# **OXFORDSHIRE COUNTY COUNCIL'S RESPONSE TO CONSULTATION ON THE FOLLOWING DEVELOPMENT PROPOSAL**

**Application no:** 15/01326/OUT

**Proposal:** OUTLINE - Up to 280 dwellings (including up to 30% affordable housing), introduction of structural planting and landscaping, informal public open space and children's play area, surface water flood mitigation and attenuation, vehicle access point from White Post Road, creation of car park and associated ancillary works. All matters to be reserved with the exception of access

**Location:** OS Parcels 6741 And 5426 West Of Cricket Field North Of Wykham Lane Bodicote Oxfordshire

FIGURE B1/A TRAFFIC COUNTS: 2013, 2014 & 2015
 AM & PM PEAK HOURS

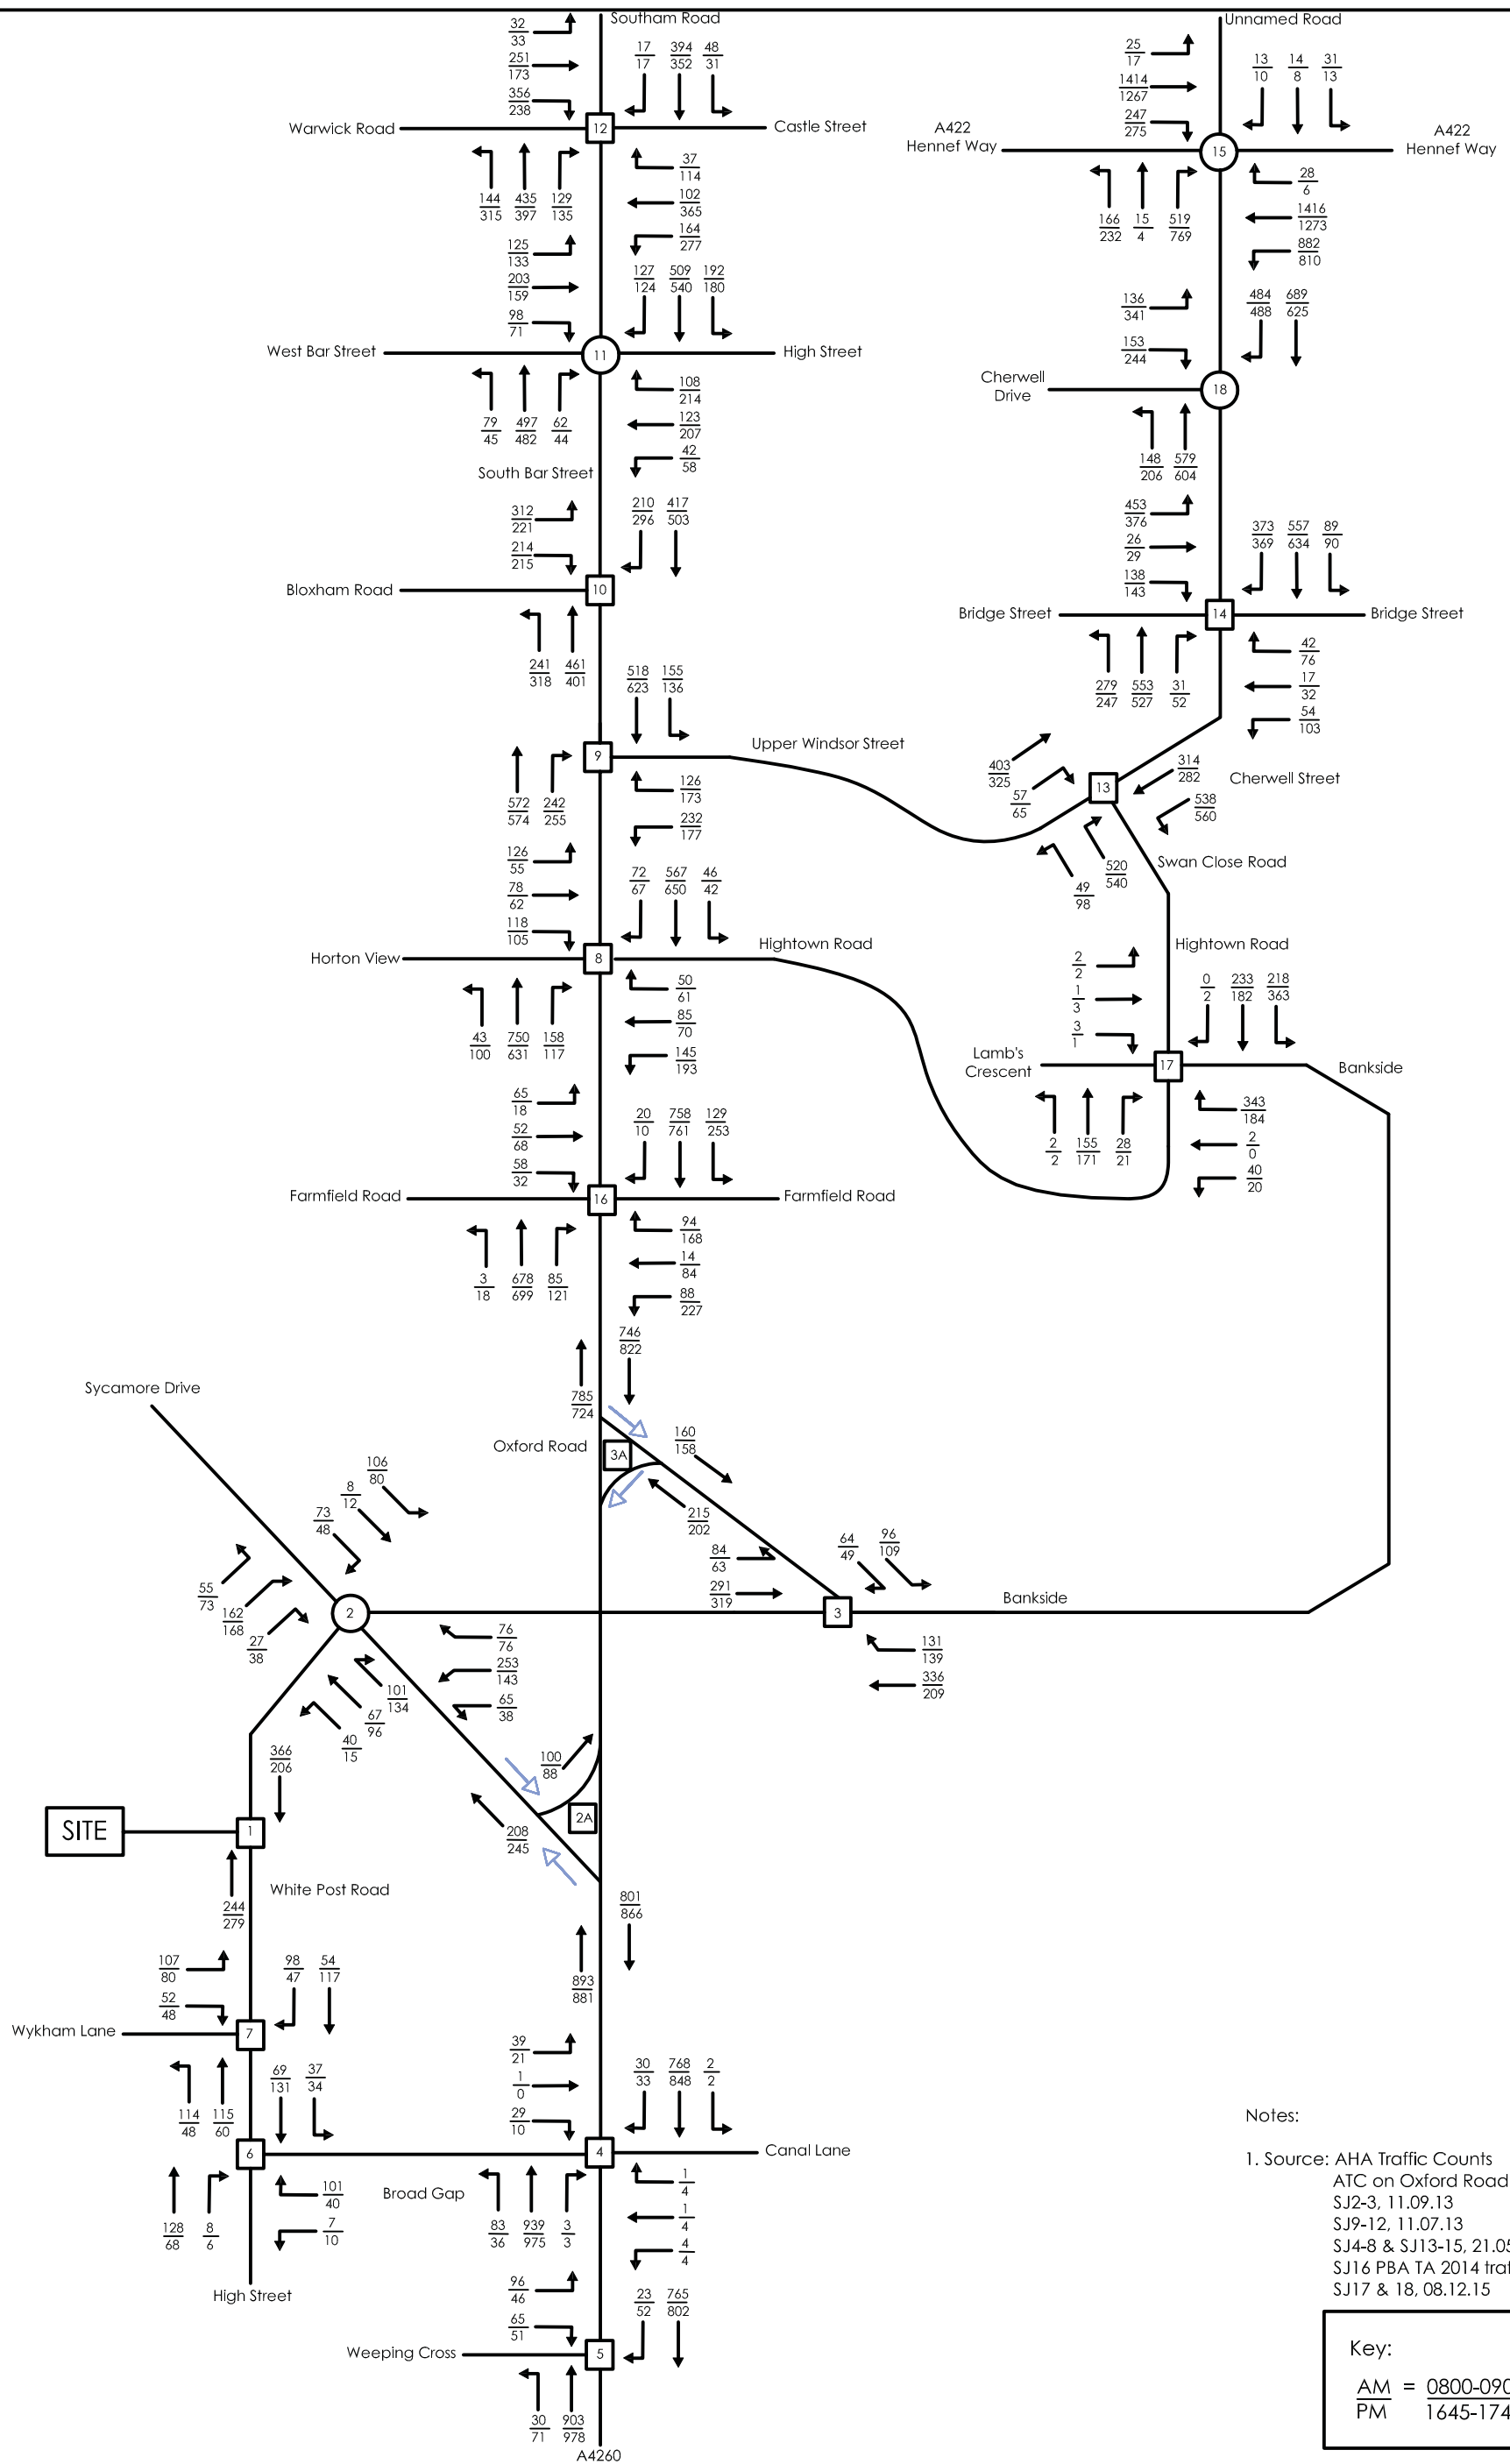
Traffic count data has not been provided to support the junction assessments, or establish the peak hour. Data from queue length surveys to validate LINSIG models has not been provided. Dates on which surveys were carried out have not been provided.

FIGURE B3/A TOTAL COMMITTED DEVELOPMENT

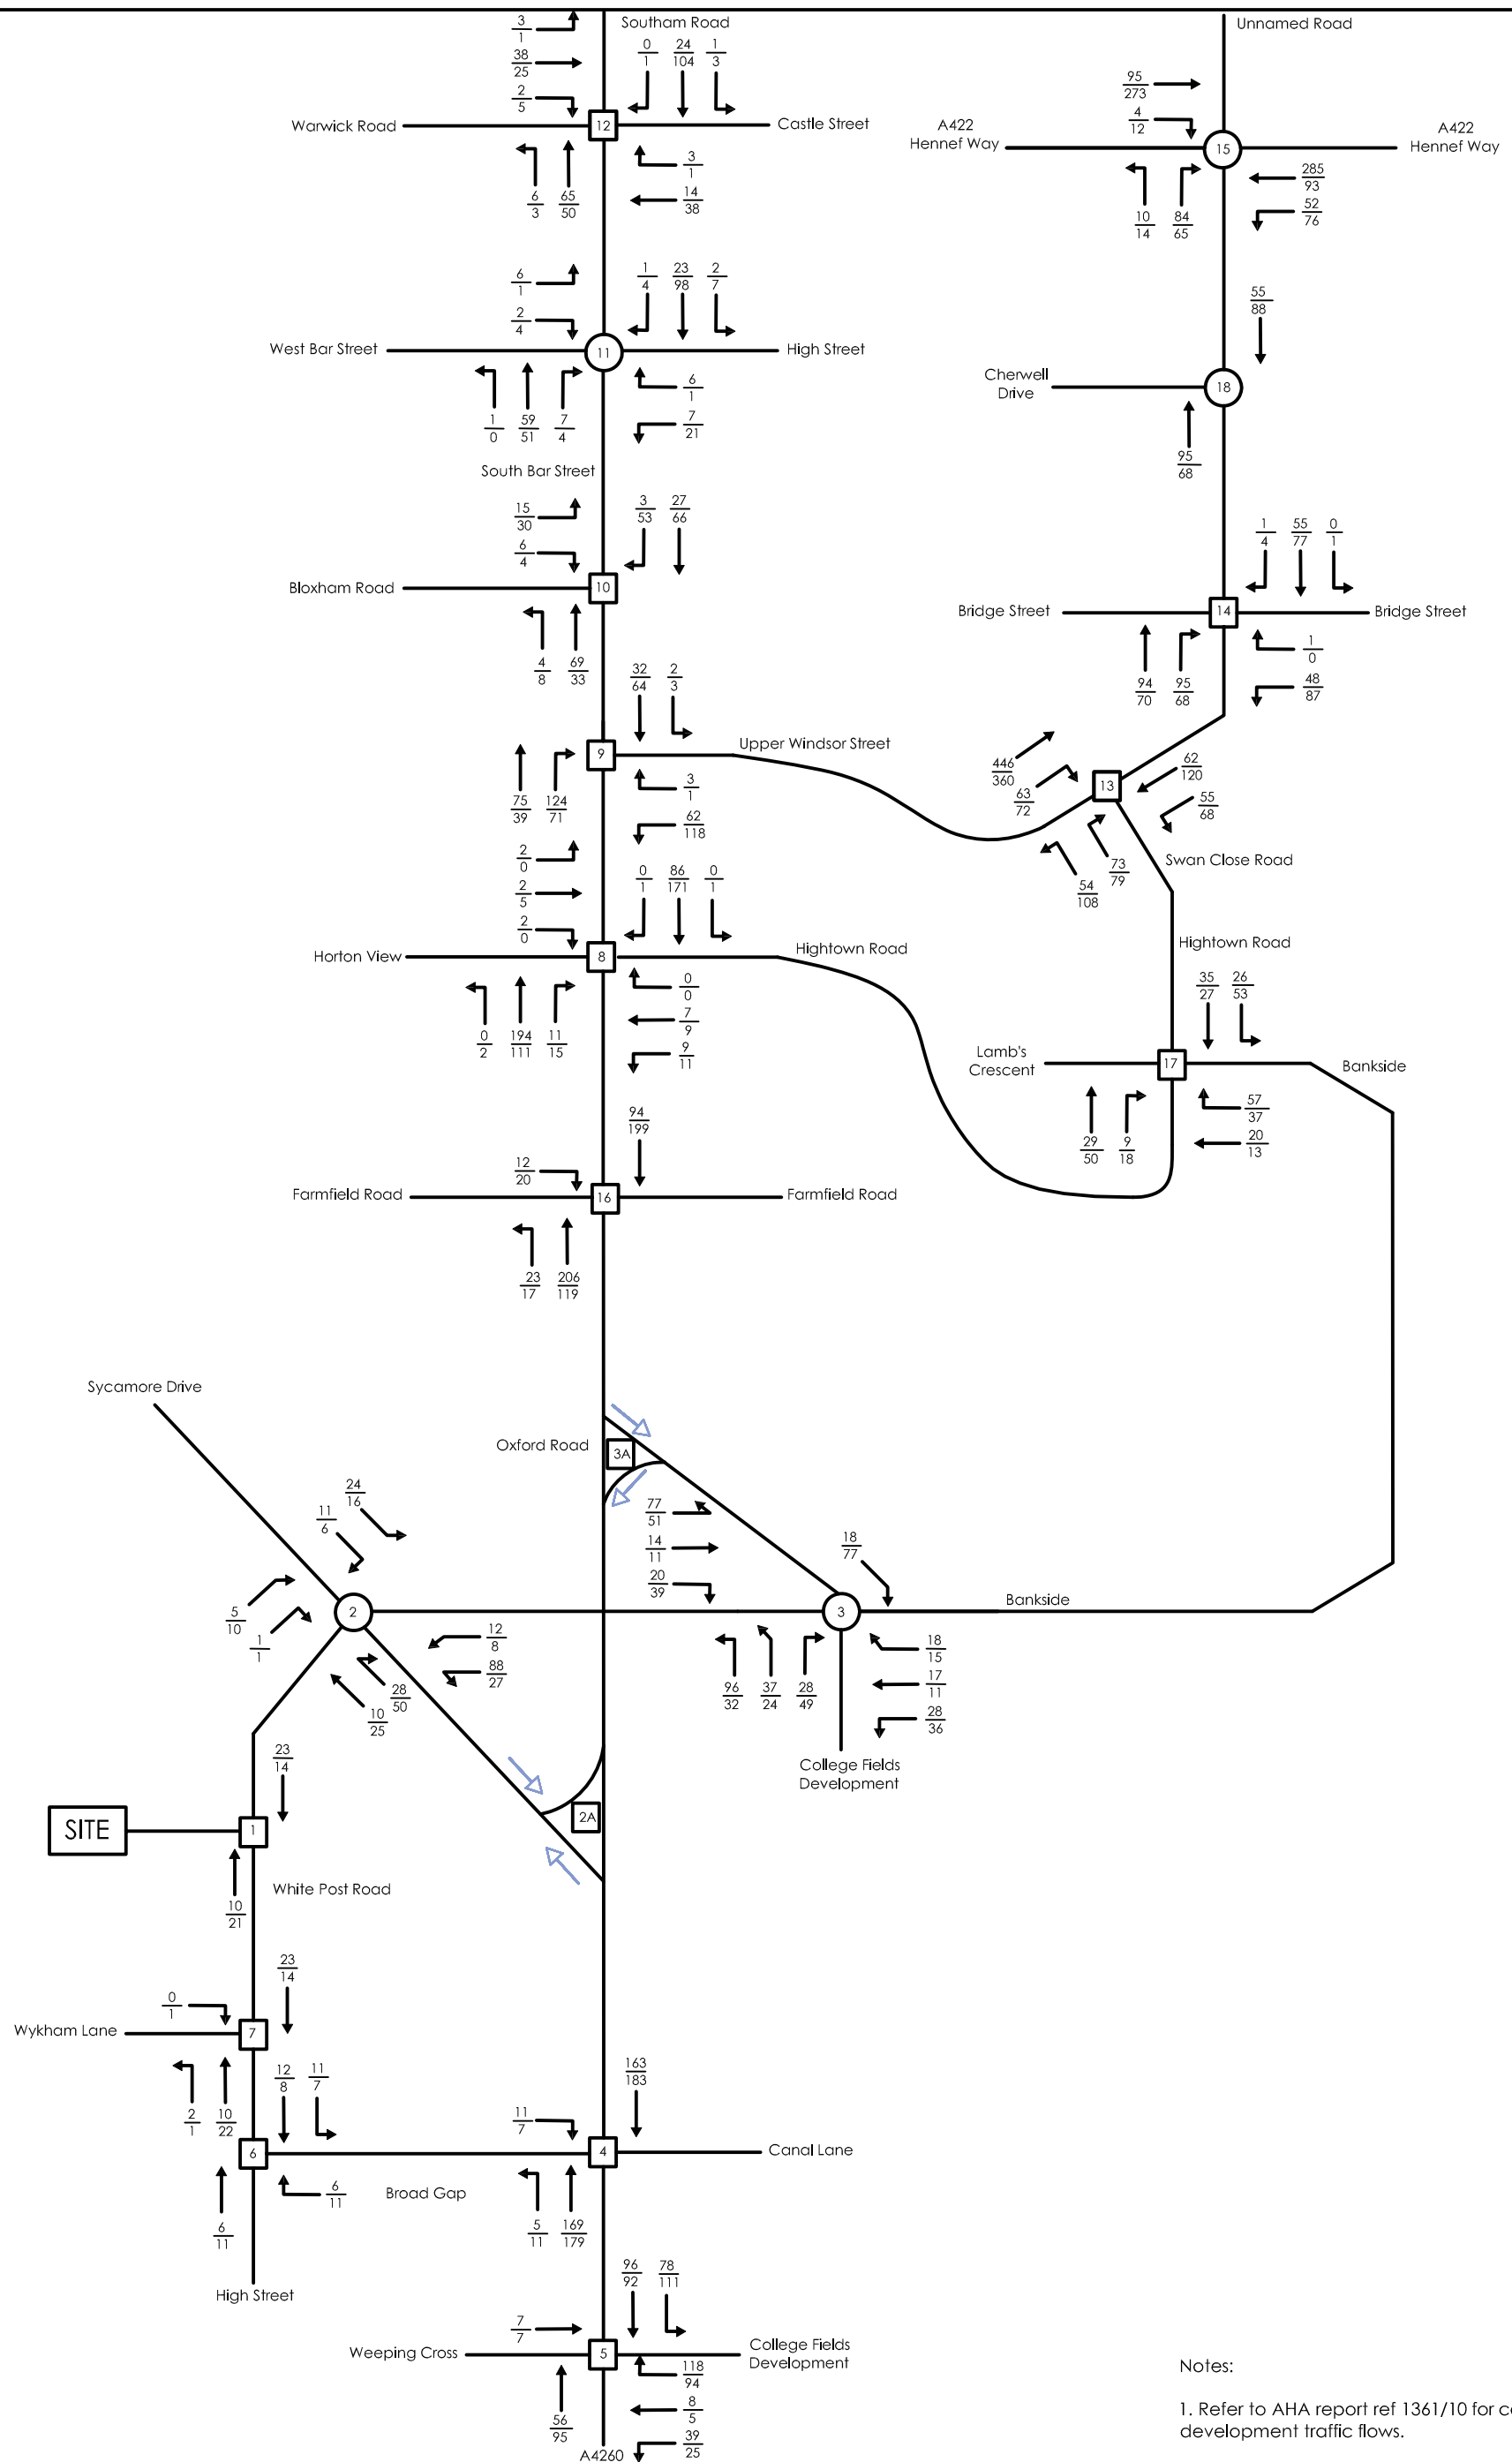
It is noted the following Committed Development sites have been omitted from the Transport Assessment. It is not clear why these have been omitted. In my view, these need to be included in the assessment.

Paragraph 10.1.4.1 refers to Land to the West of Bloxham Road this site known in the Local Plan as Banbury 16 is committed development for 350 dwellings (14/01188/out). This site should have been included in the committed development as it is not part of Banbury 17 policy area.
